A63 Castle Street Improvement, Hull

TR010016

Applicant's comments on additional information or submissions received by Deadline 5

Version	Date	Status of Version
Rev 0	27 August 2019	Final

High Street Underpass

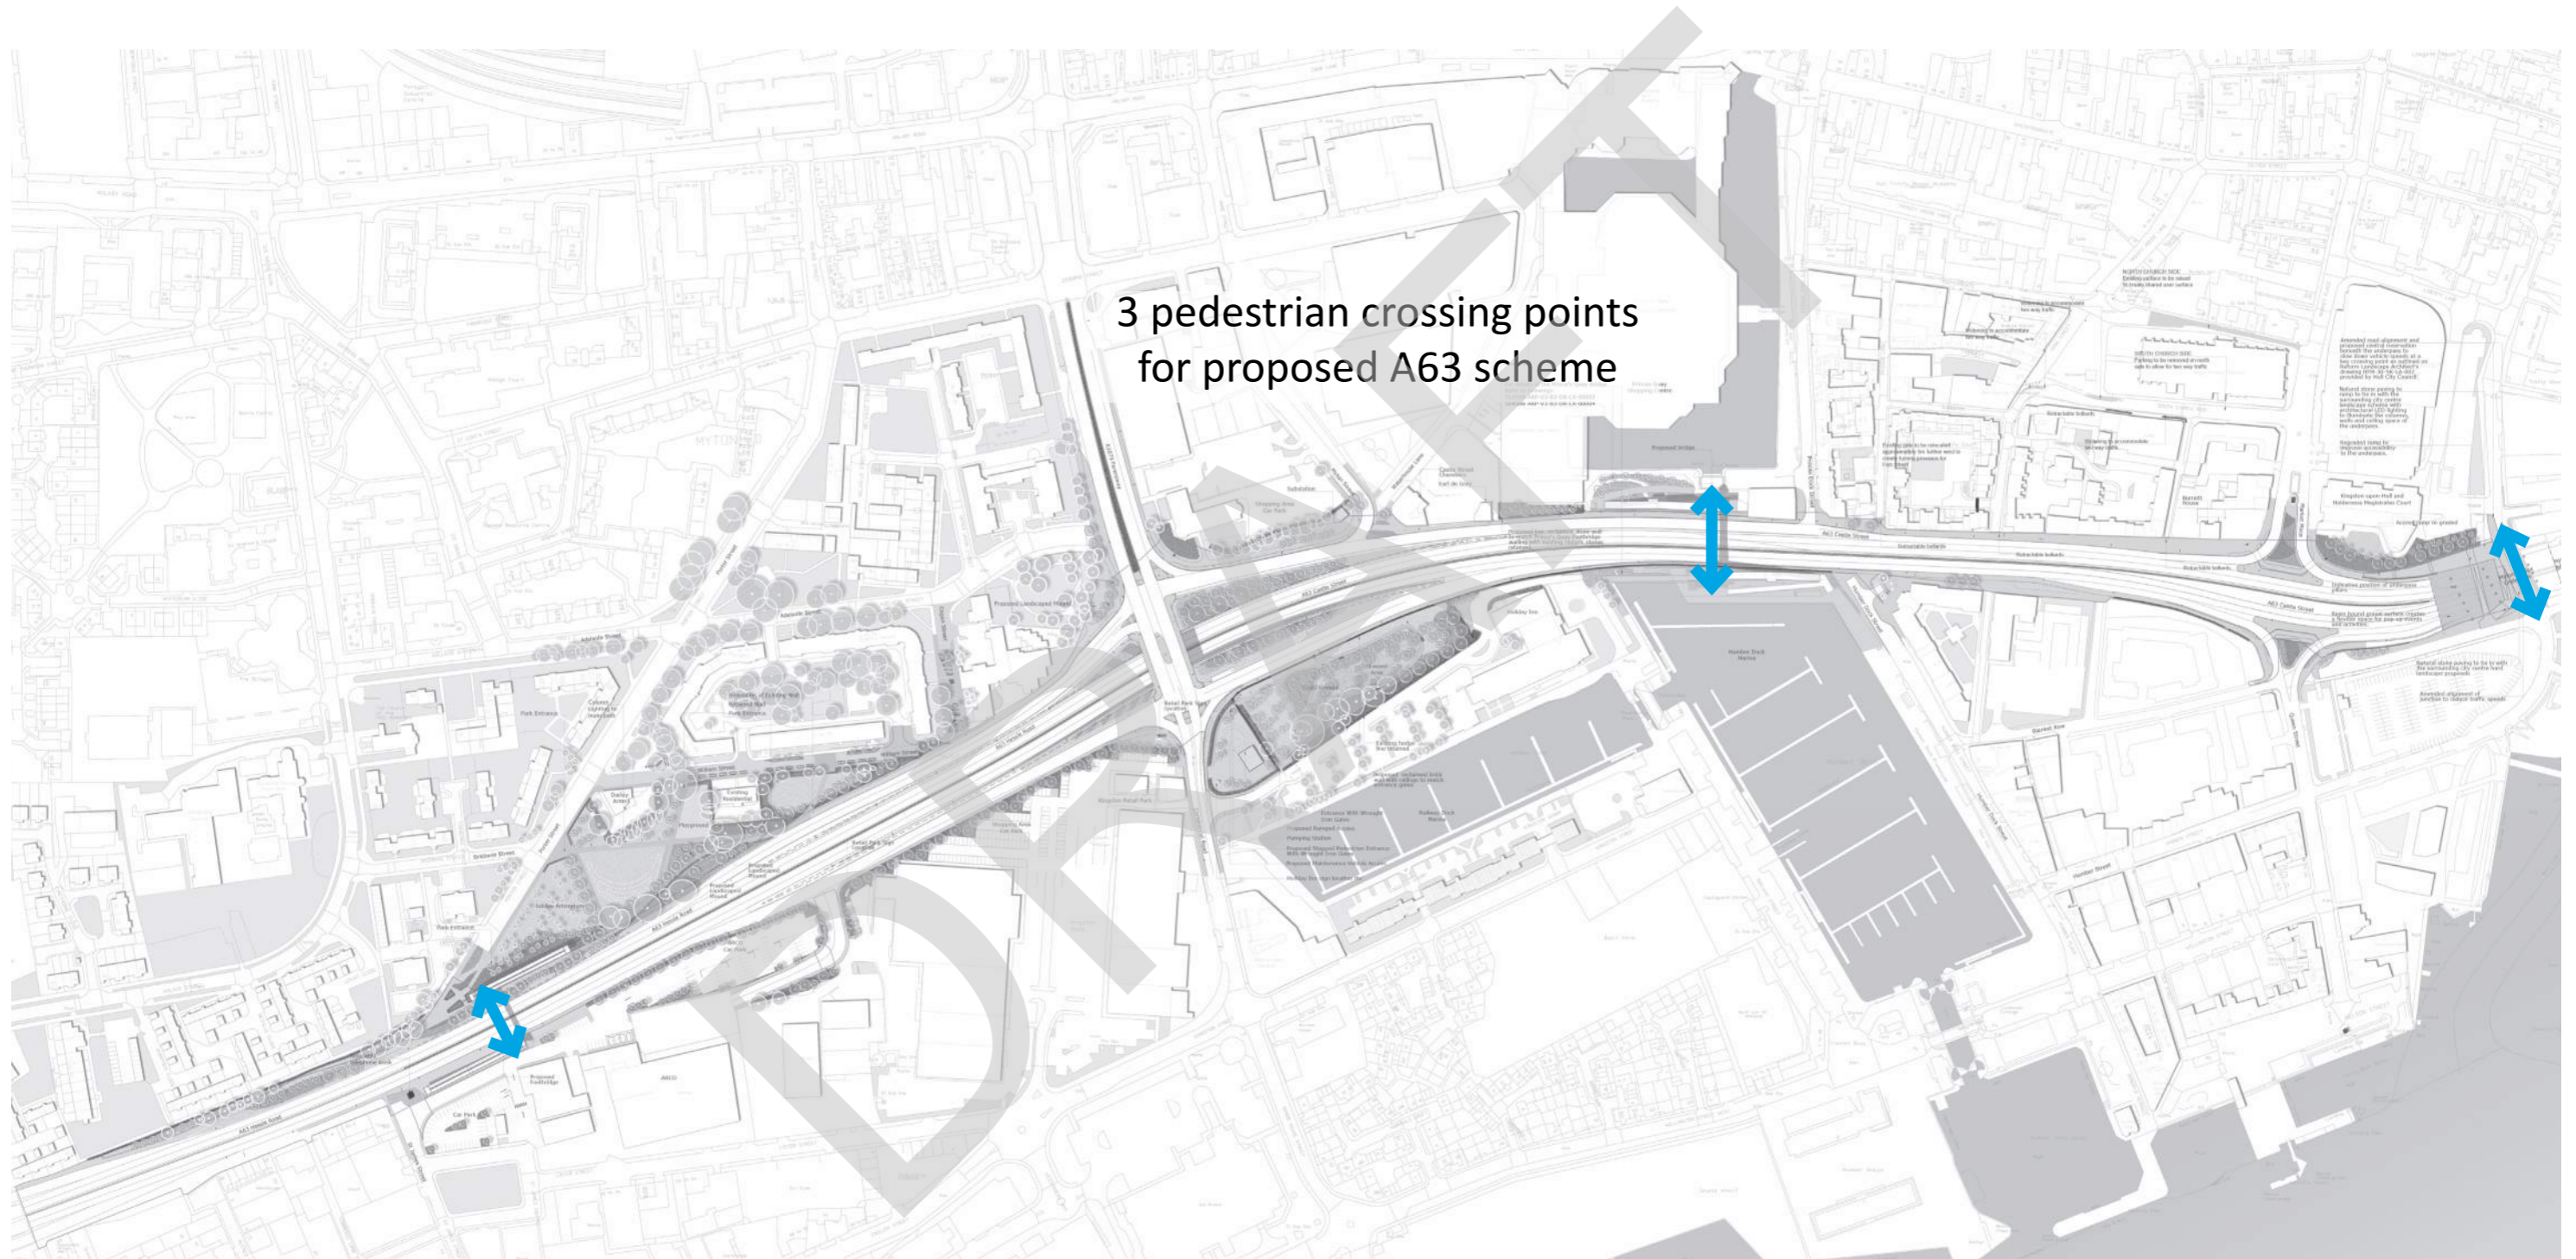
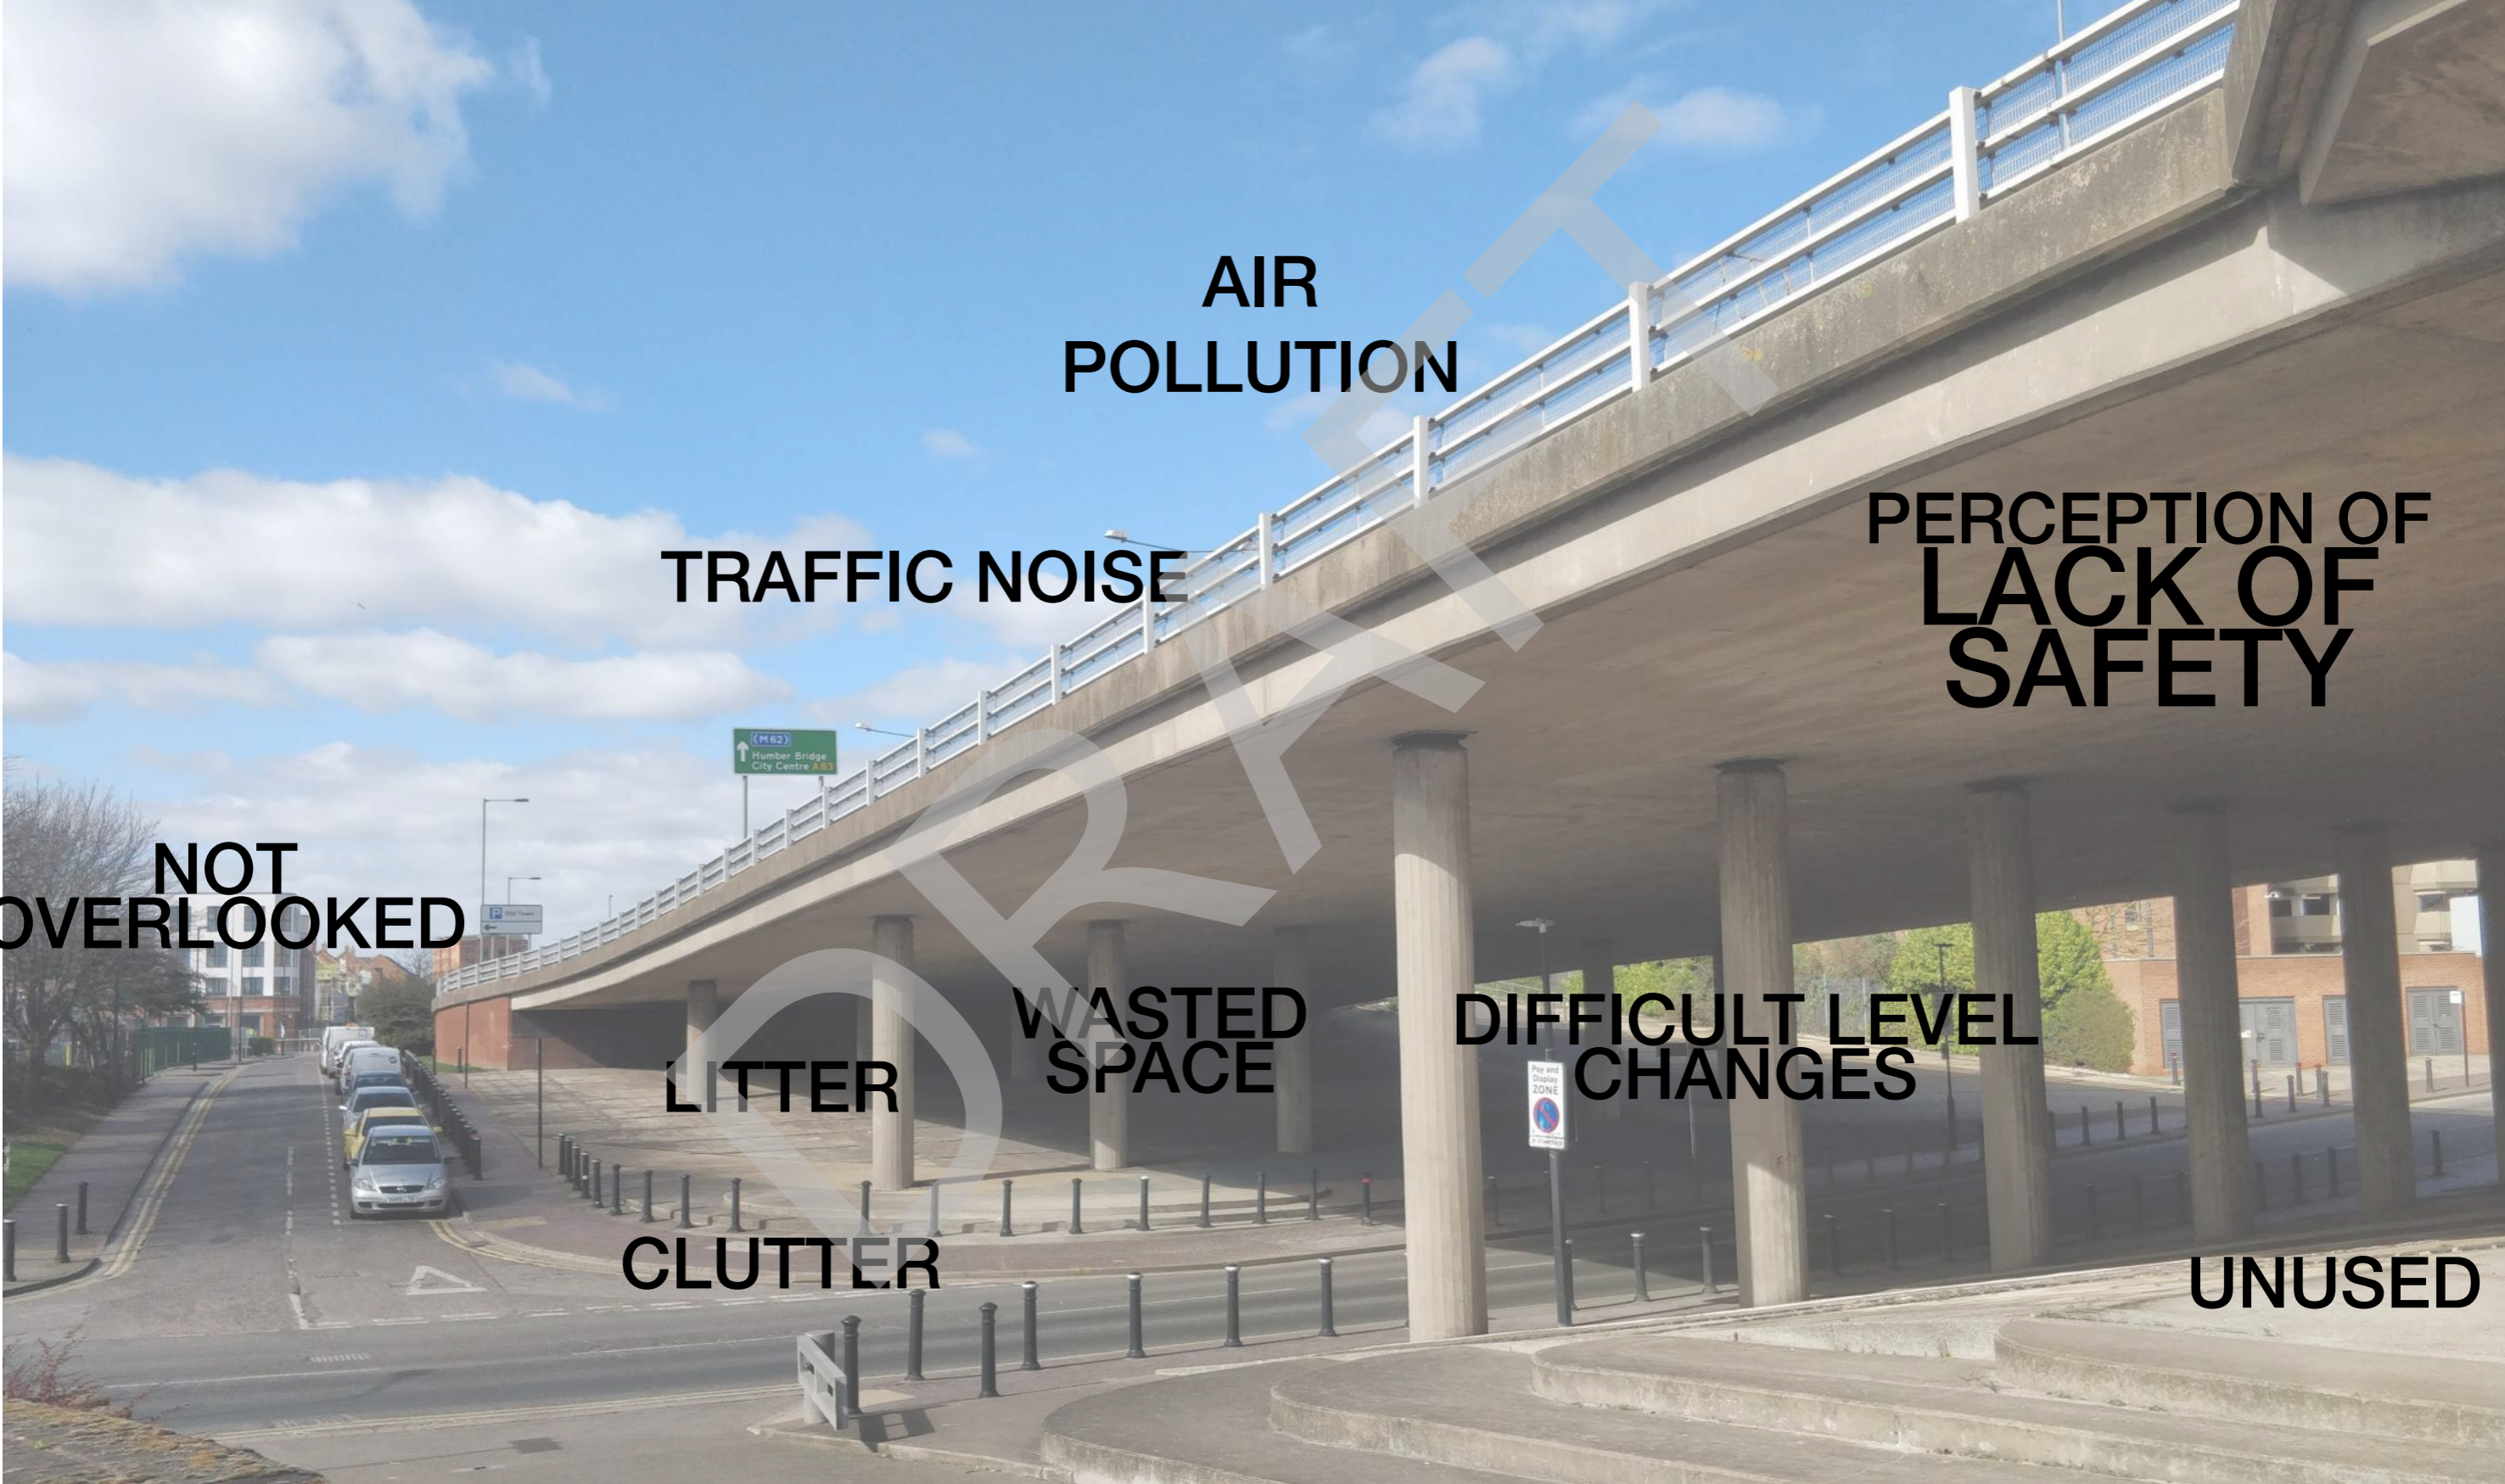
ExQ2	Question to:	Question:	HCC response
2.7	Transportation and Traffic		
2.7.2	The Applicant, HCC, HAIG, East Yorkshire and Derwent Area Ramblers	<p>Myton underpass design</p> <p>The Council's suggested additional requirement, which would require details of the design of the Myton Bridge underpass, is noted (HCC's Post-Issue specific Hearings submission [REP3-215]). Have any design principles or details yet been agreed? If not, what evidence is there that a mutually satisfactory design can be achieved?</p>	<p>HCC wishes to reiterate that this element of the scheme remains a distinct and fundamental concern. Given the removal of at grade NMU crossings over the A63 at the eastern end of the city centre, this route is set to become critical in connecting the city centre to its waterfront and associated regeneration areas, and providing an accessible alternative for all users, both during construction and operation.</p> <p>HCC consider that an environmental upgrade of the underpass is justified and necessary for the scheme to deliver truly on its objective to enhance connectivity, and mitigate for extended travel distances for NMUs, and comply fully with the DfT's Cycling and Walking Investment Strategy, the Applicant's Accessibility and Cycling Strategy, paras.3.16 and 3.17 of the NN NPS, and Policy 25 of the Local Plan.</p>

ExQ2	Question to:	Question:	HCC response
			<p>In the continued absence of sufficient design details for the proposed base scheme, and reliance on frozen designated funds for uplift, notwithstanding constructive consultation around the issue with the both council officers and representatives from HAIG, including a beneficial walk through held on 2nd July, and discussion around broad design principles at a subsequent landscaping design meeting, HCC consider that it is essential that the additional requirement features within the DCO.</p> <p>The Council and its partners in the 'Living with Water' project have identified the underpass as a location suitable to benefit from secured public art funding associated with flood risk and water management. Adjacent to the River Hull and near to its confluence with the Humber estuary, in the shadow of the River Hull tidal surge barrier, and on one of the main pedestrian approaches to the Deep aquarium, the site is considered to have great potential, and the Council is very keen to work with the Applicant to pool ideas and resources towards maximising the quality of experience for route users.</p>

<p>HCC note the following <i>'in the continued absence of sufficient design details for the proposed base scheme, and reliance on frozen designated funds for uplift, notwithstanding constructive consultation around the issue with the both council officers and representatives from HAIG, including a beneficial walk through held on 2nd July, and discussion around broad design principles at a subsequent landscaping design meeting, HCC consider that it is essential that the additional requirement features within the DCO'</i>. It should be noted that preliminary design (of which the DCO is based on) has been shared with all parties, including HCC and HAIG. Meetings have been held in a workshop format and on site and the feedback on the proposals was overwhelmingly positive. Detailed visualisation were also presented to all parties which again were well received. The comments from the group centred around the step detail on the corner Blackfriargate and High Street which will be picked up at detailed design stage.</p>

<p>The Applicant's Response 2.7.2</p> <p>The Applicant notes the importance of the High Street underpass to HCC as the proposed route around Market Place crossing closure. The Applicant has worked very closely with HCC highways officers, access officers, HAIG, designers and developers adjacent to this route during the scheme development. Workshops have been held, a walk with HAIG was held and visualisations for the route have been prepared and shared. They have been appended to The Applicants D6 submission for the ExA to consider.</p>

ExQ2	Question to:	Question:	HCC response
		<p>The base scheme proposals, therefore entirely funded by the Scheme, indicate that the route between Market Place and Queen Street will be upgraded to:</p>	<ul style="list-style-type: none"> - Improve accessibility in line with guidance (dropped crossings and smoother ramp gradient); - Provide enhanced street lighting and urban lighting (up / down lighters for the bridge piers) on the route; - Improve the footways and align this with material used following the significant public realm work completed by HCC; - Provide CCTV infrastructure; - Cut back the levels of overgrown vegetation and provide a new low maintenance planting proposal for the route.
		<p>The visualisations provided by The Applicant show that this area is to be significantly improved compared to current levels. The Applicant, by agreeing to uplift the footway material and provide additional up/down lighters under the structure is going above and beyond of the minimal provision that would be expected. This has been agreed between The Applicant and HCC as it will become the only way for people to cross between the north and the south of Castle Street in this vicinity.</p>
